5 July 2019

Exhibition comments – Kemps Creek Warehouse, Logistics and Industrial Facilities Hub (SSD 9522)

WaterNSW has reviewed the Environmental Impact Statement (EIS) and associated documents submitted by WillowTree Planning on behalf of the Applicant. ***WaterNSW objects to this development application in its current form due to proposed changes in flood levels post-development that will have the potential to significantly impact WaterNSW assets, infrastructure and land within the Pipelines corridor.***

Figure B5 – 1% AEP Flood Levels (Post-Development)

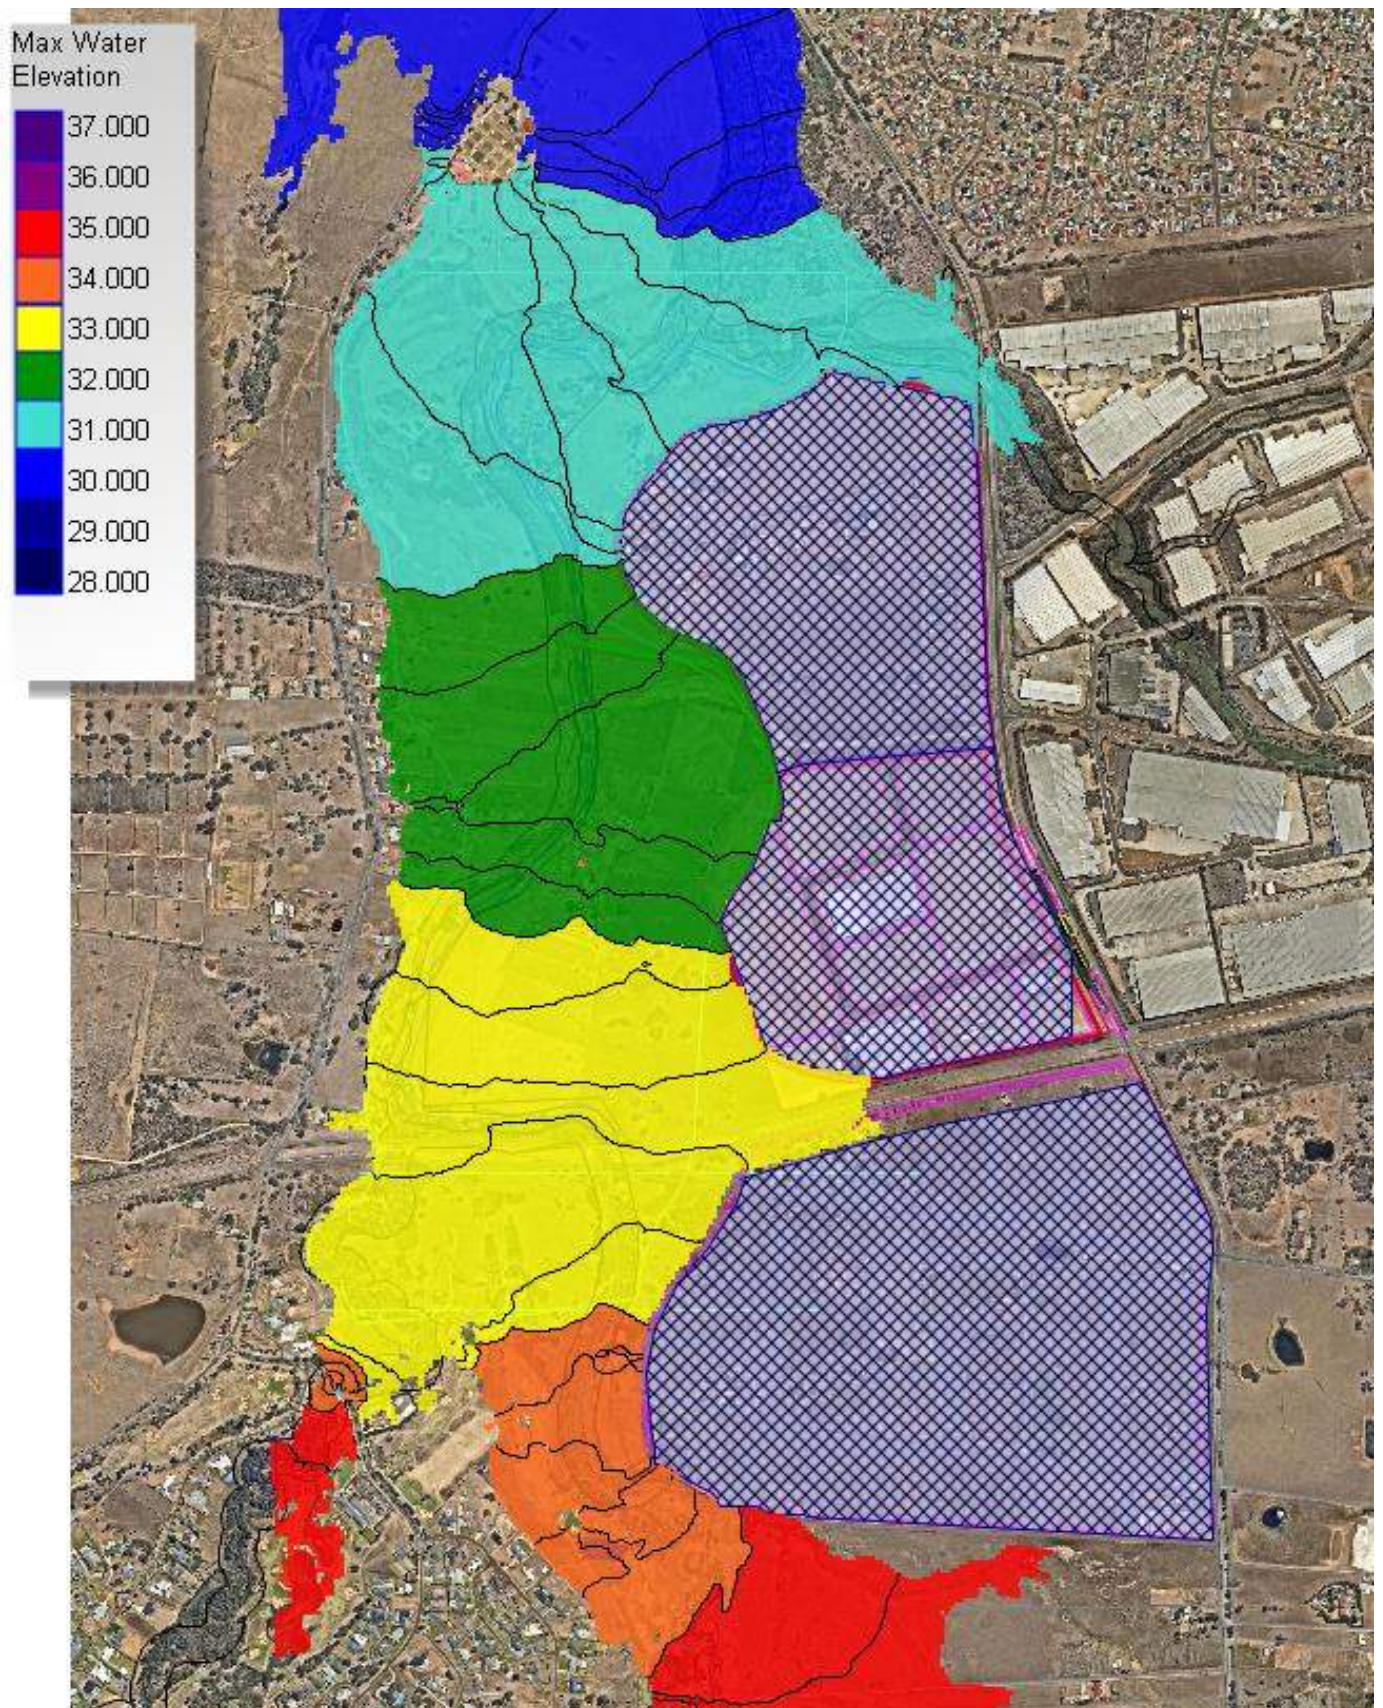
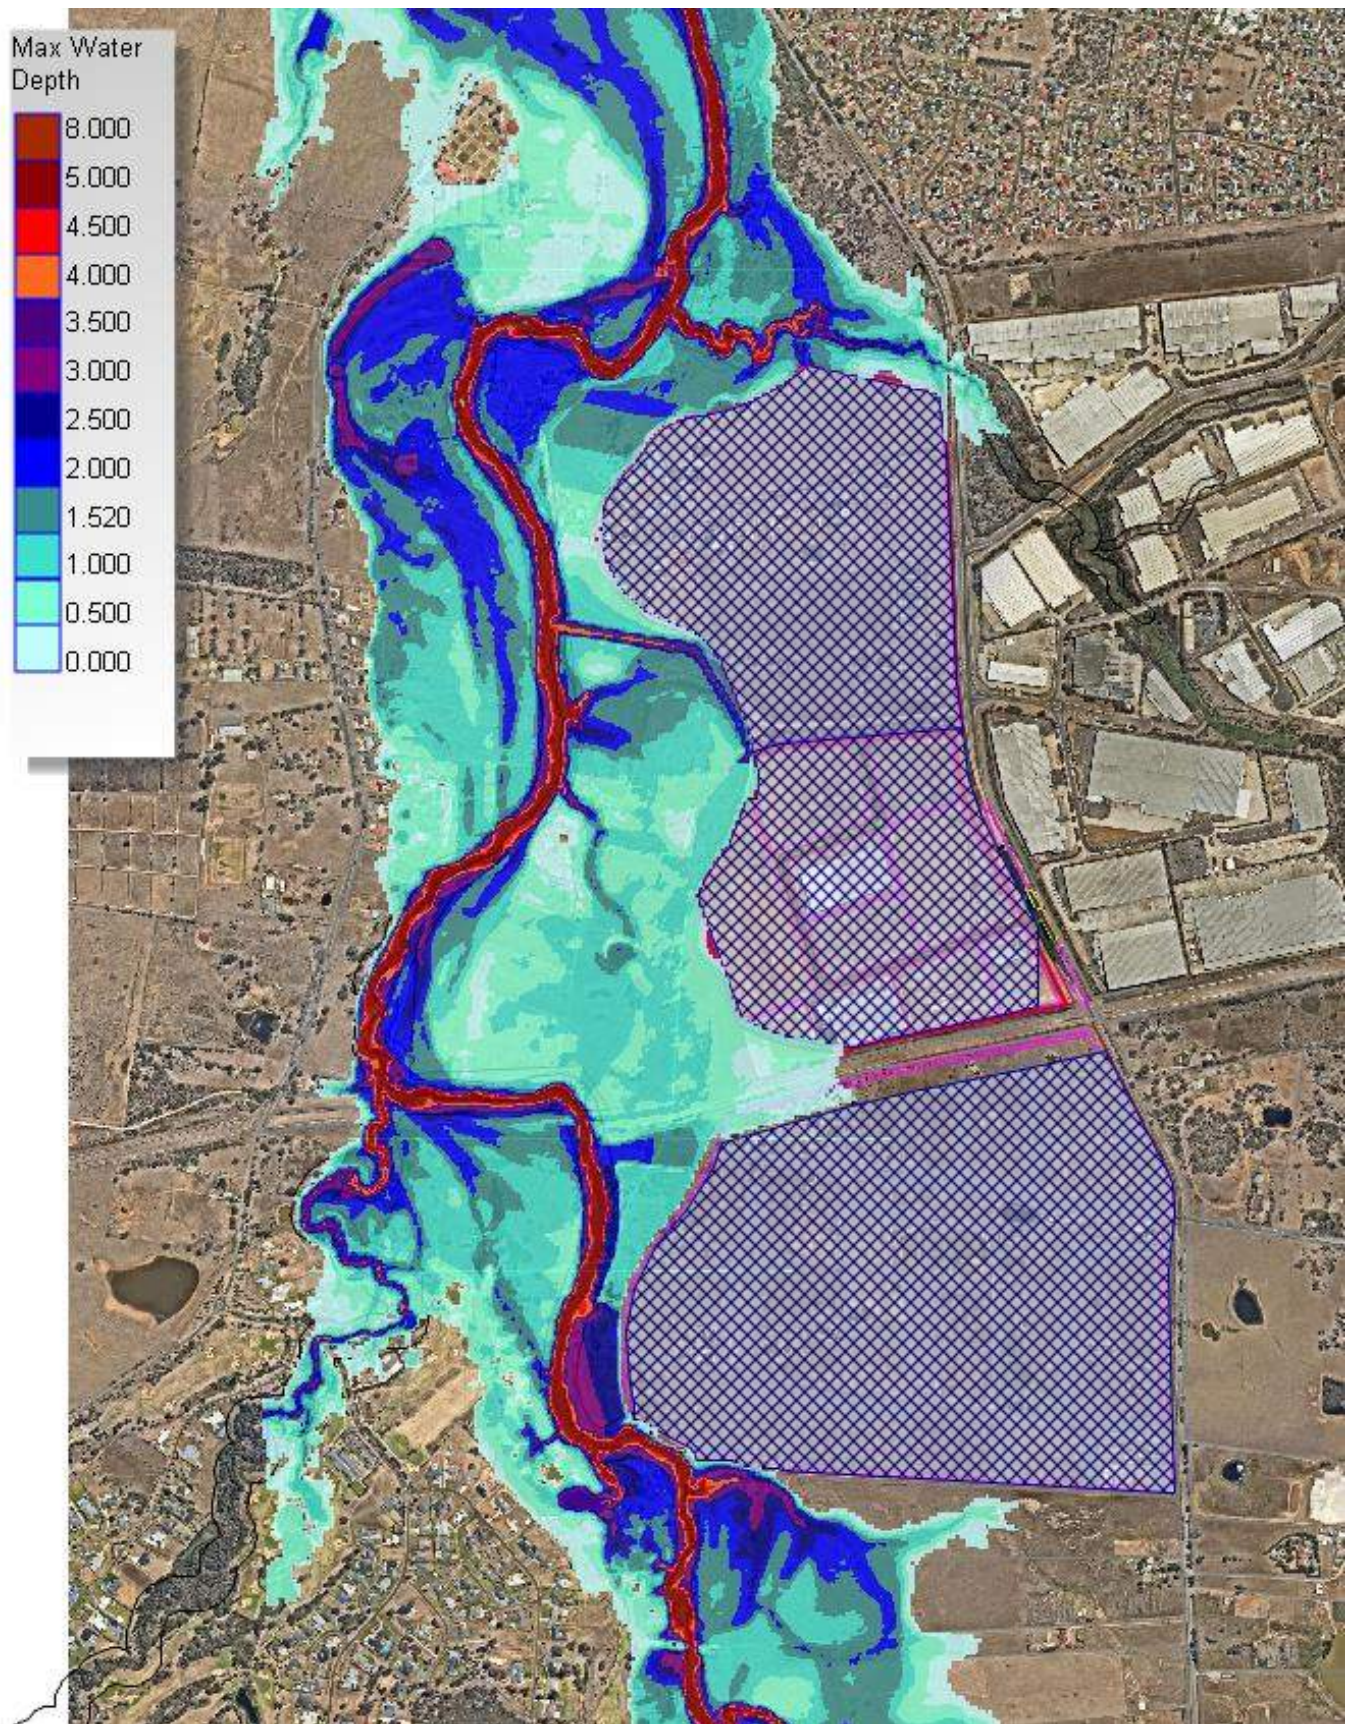
WaterNSW understands there will be a potential decrease in flood surface levels adjacent to the development on the eastern and western banks of South Creek, and upstream of the proposed development due to an increase in flood water storage capacity onsite. However, within the WaterNSW corridor directly adjacent to the development, an increase in flood levels is demonstrated in a post development scenario.

WaterNSW notes that for 1% AEP flood level of South Creek, the flood surface height varies in level from RL 35.20m AHD at the upstream southern end of the site to RL 33.60 m AHD at the downstream northern end of the site. Anecdotal reports from WaterNSW staff advise that during a minor rain event in early 2016, the floodwaters from South Creek reached the centre line of the Pipelines (RL 34.24).

The Overland Flow Report (2019) notes that stormwater management measures have been designed to ensure that post-development stormwater flows will be attenuated to pre-development stormwater flows. These measures include conveyance of surface runoff, management of water quantity (through on-site detention) and water quality (through on-site and estate wide management systems) using Water Sensitive Urban Design principles and current best practice pollution reduction objectives. However, the modelling within Appendix B of the Overland Flow Report (2019) contradicts this and demonstrates an impact on WaterNSW assets.

WaterNSW requires that post-development flows that enter or are conveyed across the Pipelines corridor must be equal to or less than the pre-development flows for each storm event up to and including 1% AEP event.

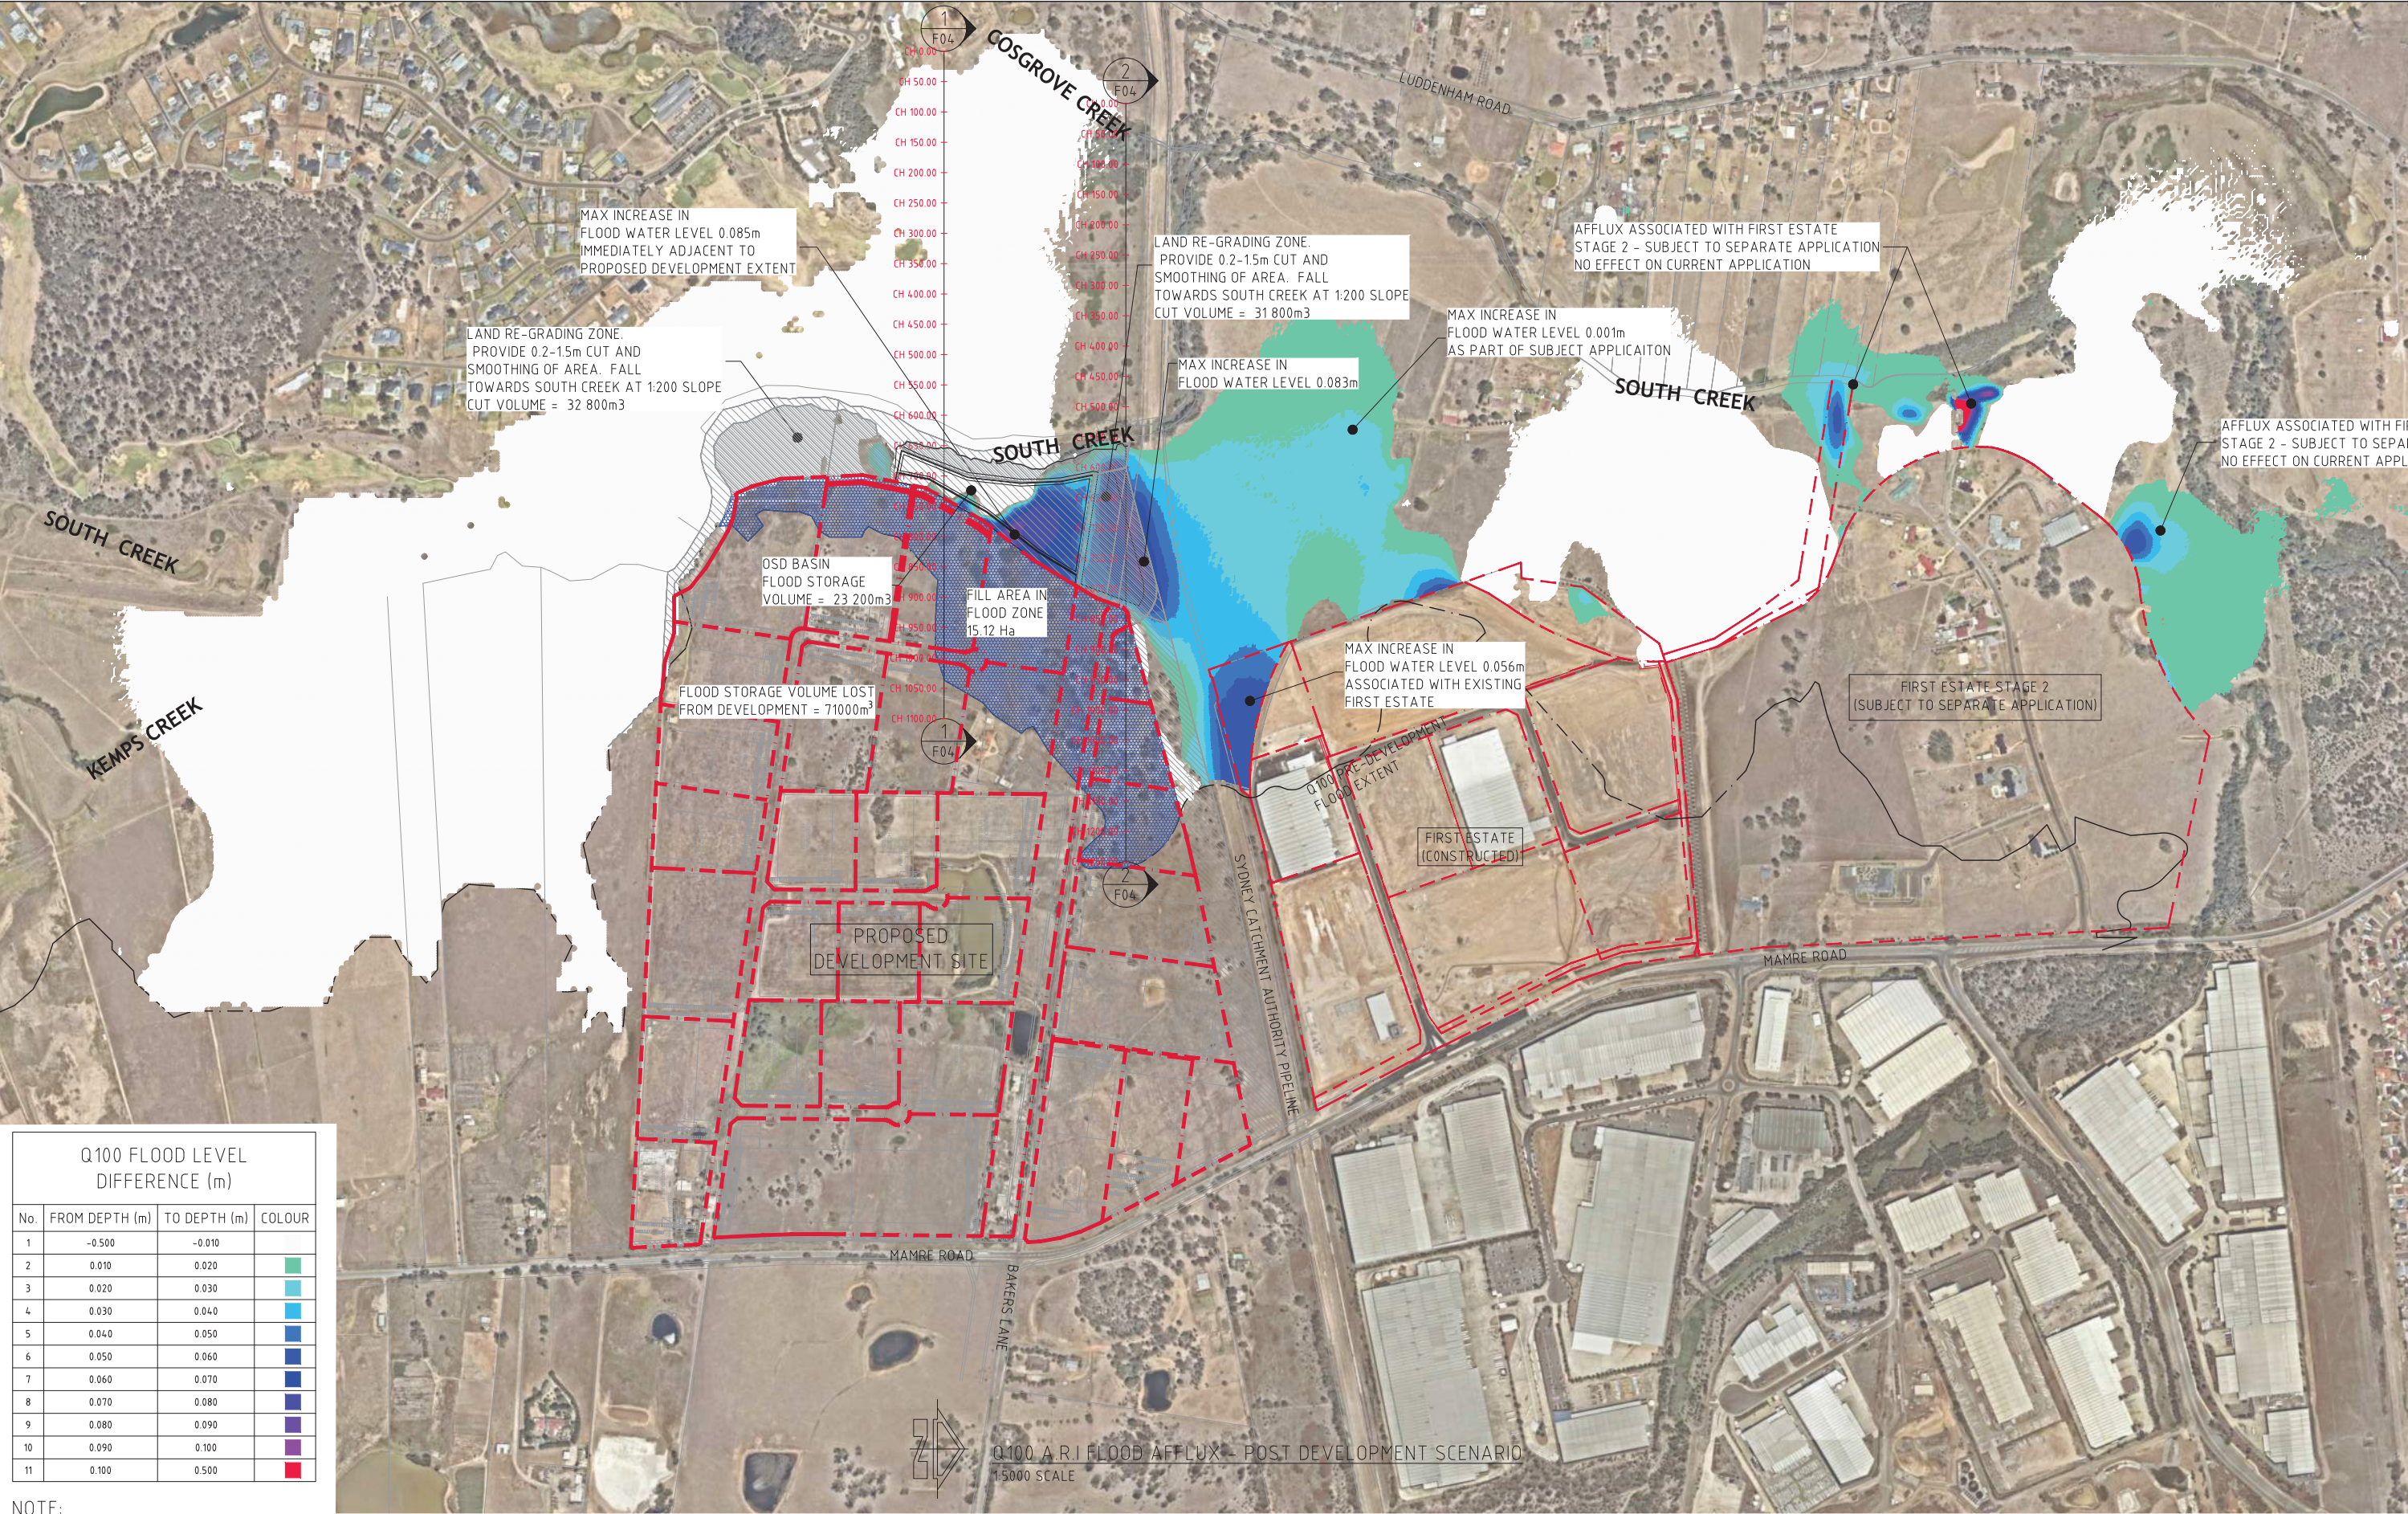
There is also potential for floodwaters to extend further up the Pipelines corridor than currently mapped due to the raised level of the development site resulting from earthworks, narrowing the flow path for stormwater. This also has the potential to result in scouring of the Pipelines corridor and destabilisation of the anchors and sills supporting the Pipelines. All development works must be undertaken in a manner that avoids any impact on the Pipelines infrastructure.
